2022/0115

Description: Residential development of up to 215 dwellings with associated car parking/garages, landscaping, public open space including both equipped and non-equipped areas of play, SUDS and drainage, with details of a new vehicular access onto Shaw Lane (Outline with all matters reserved apart from means of access)

Site Address: Land north of Shaw Lane, Carlton, Barnsley, S71 3HH

SHAW LANE:  
 HGV EAST  
 CAR WEST

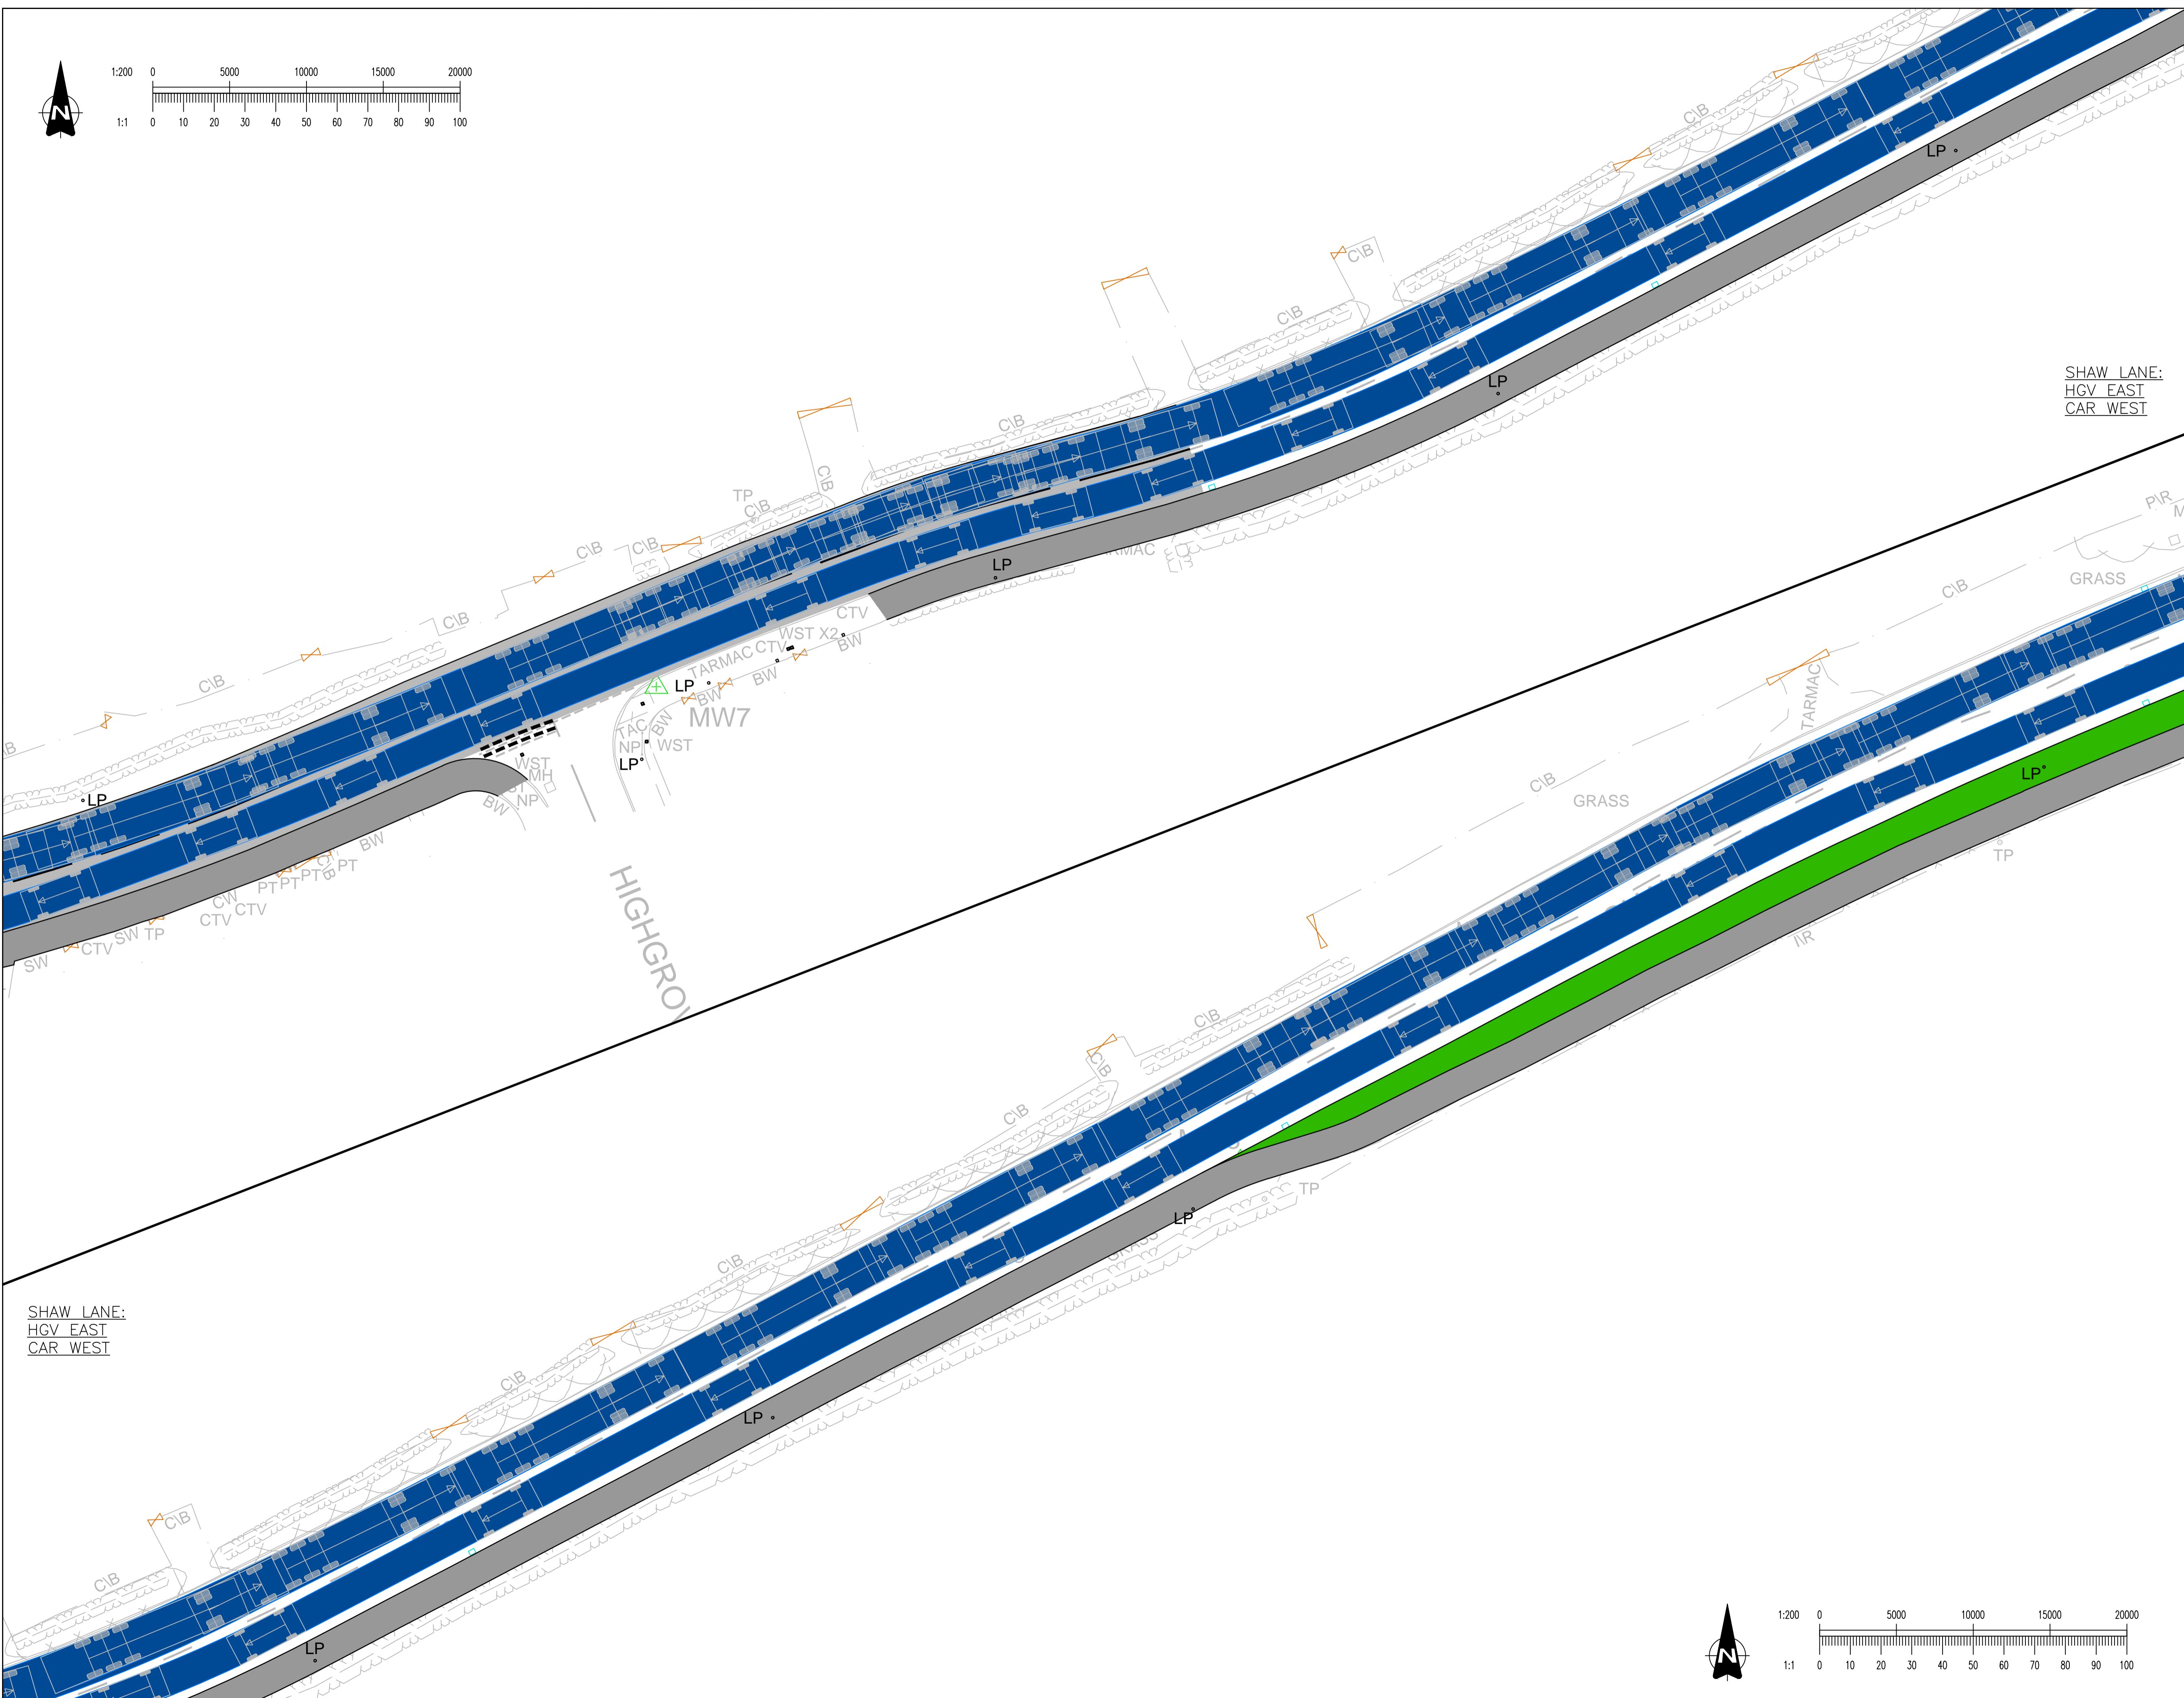
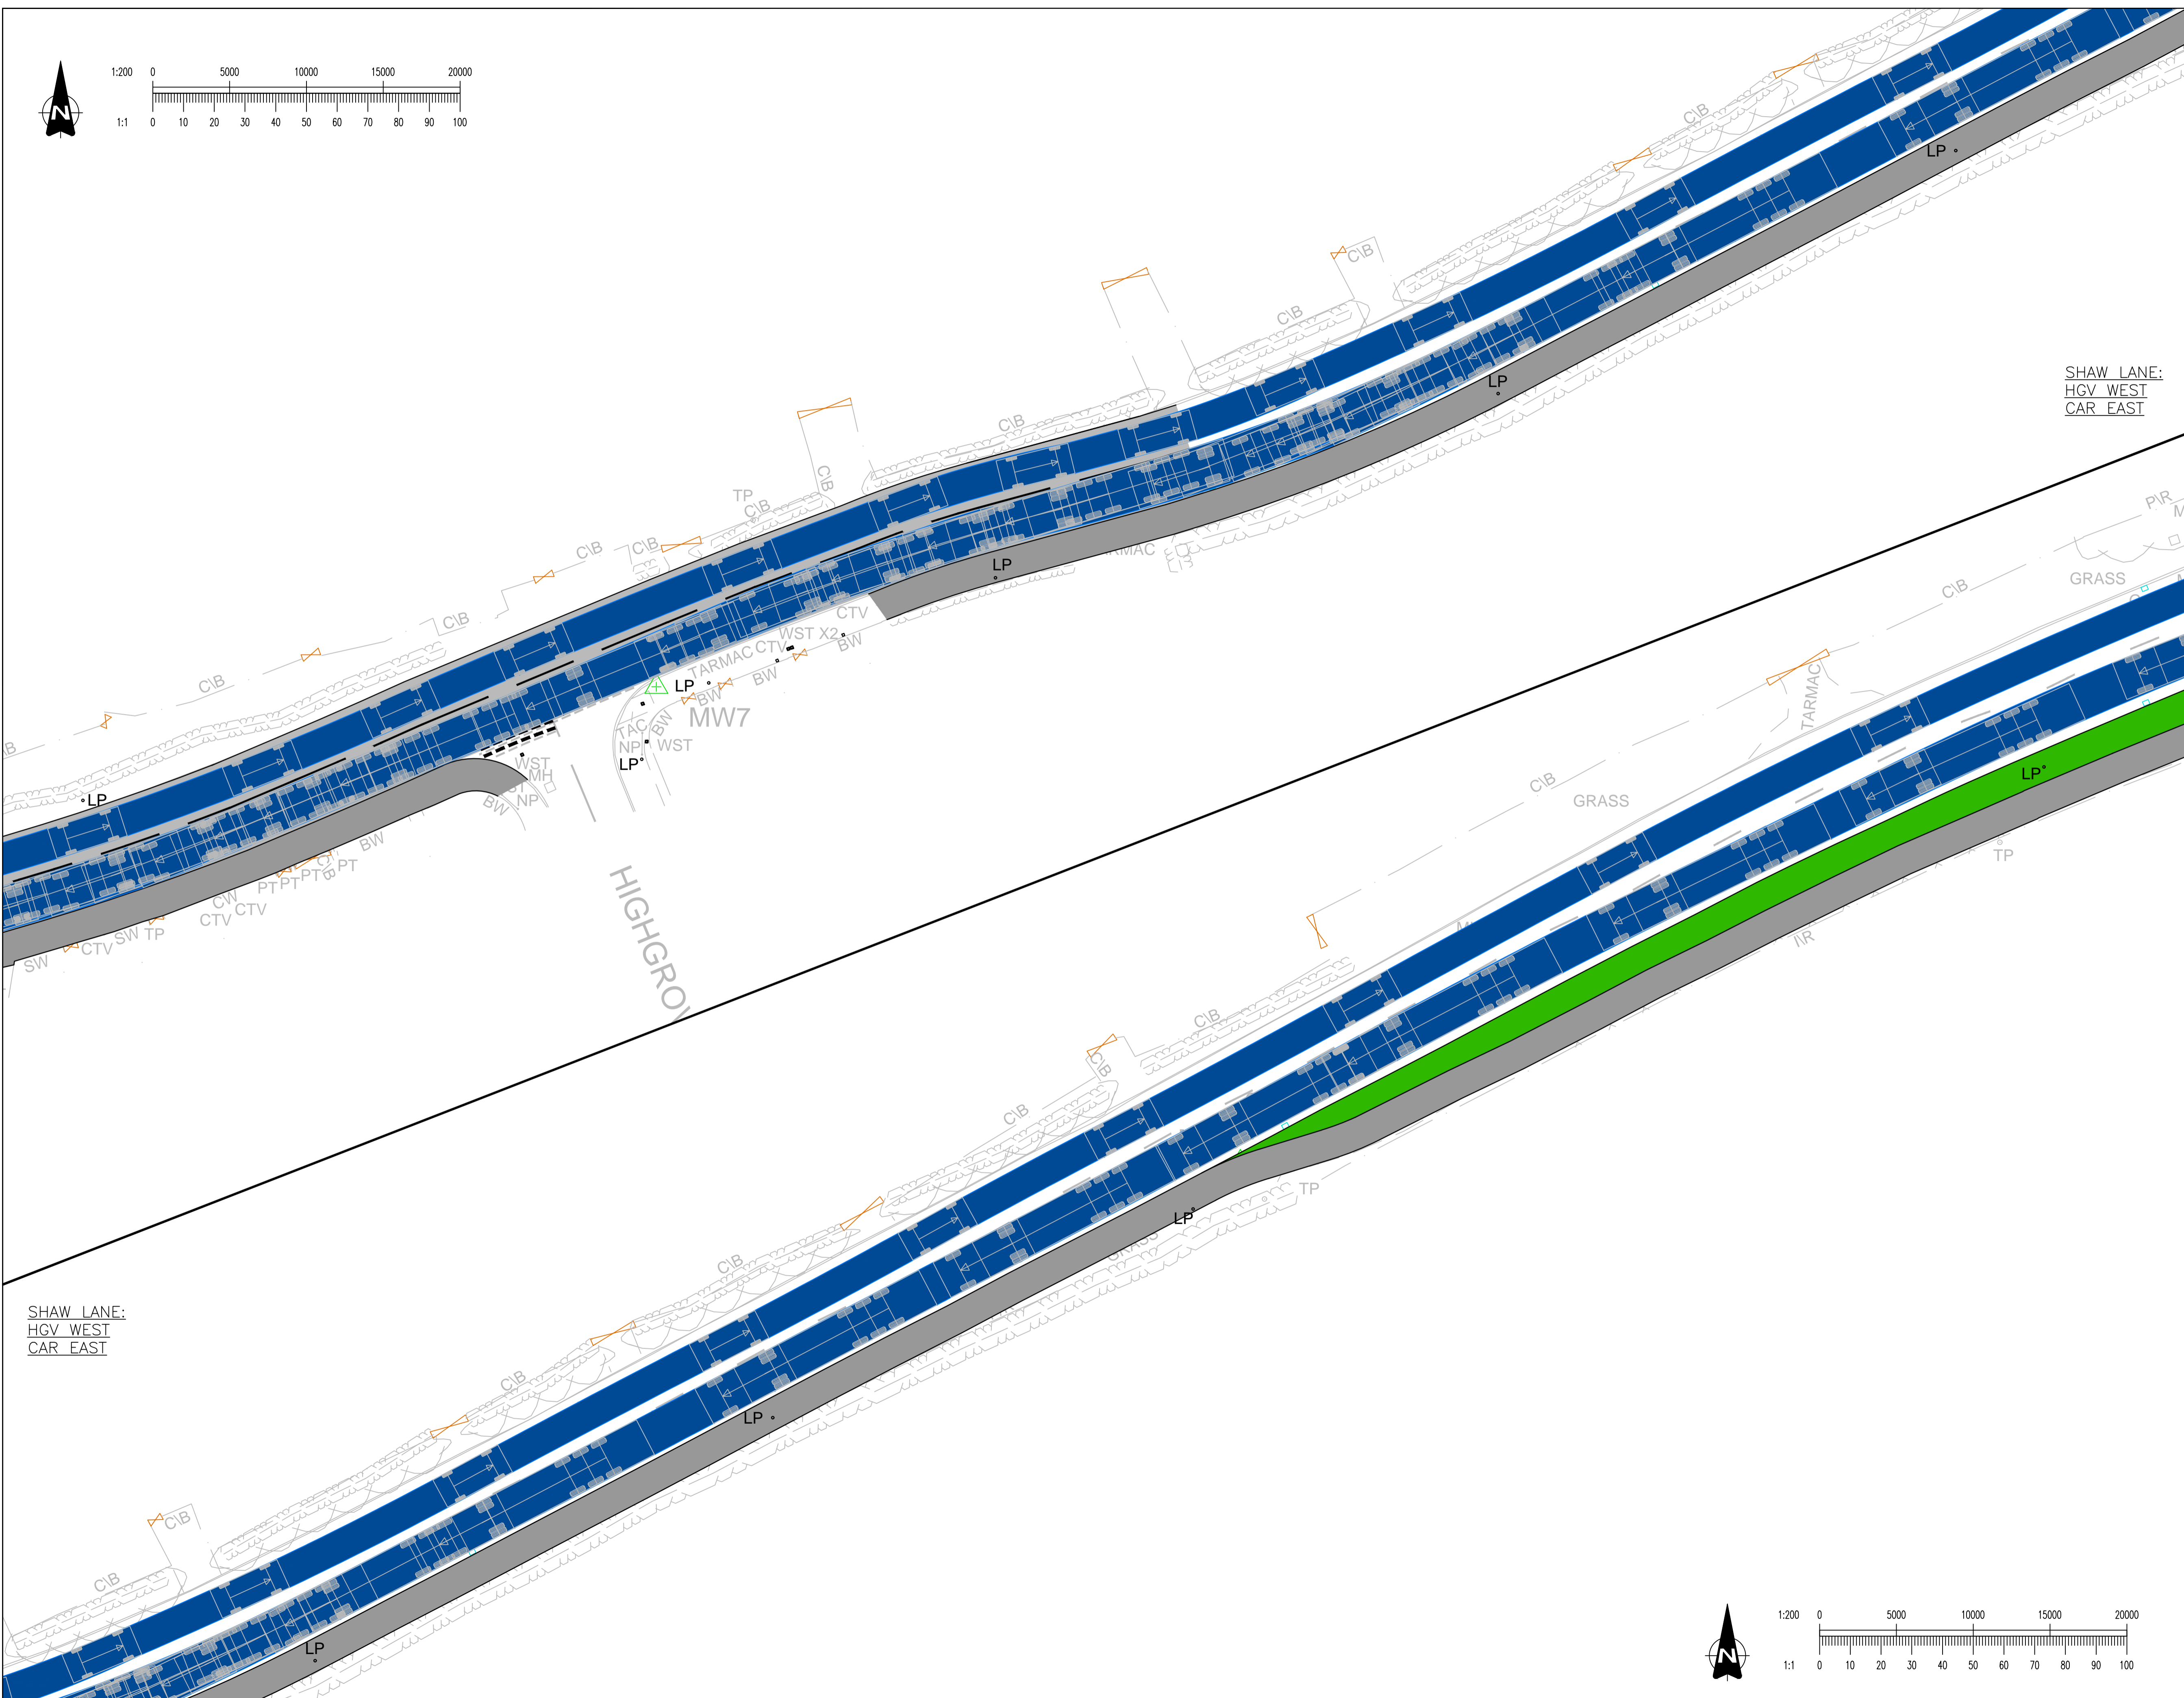
The site access junction from Shaw Lane has not been designed in accordance with the design requirements of the South Yorkshire Residential Design Guide and gives rise to road safety concerns. The South Yorkshire Residential Design Guide states that the design vehicle should be able to turn without crossing into the opposing lane on the major arm when undertaking left in / left out manoeuvres and leave 0.5m clearance between vehicle body and carriageway edge on the minor arm. Swept paths demonstrate that this requirement has not been fulfilled, therefore, the junction design is not acceptable.
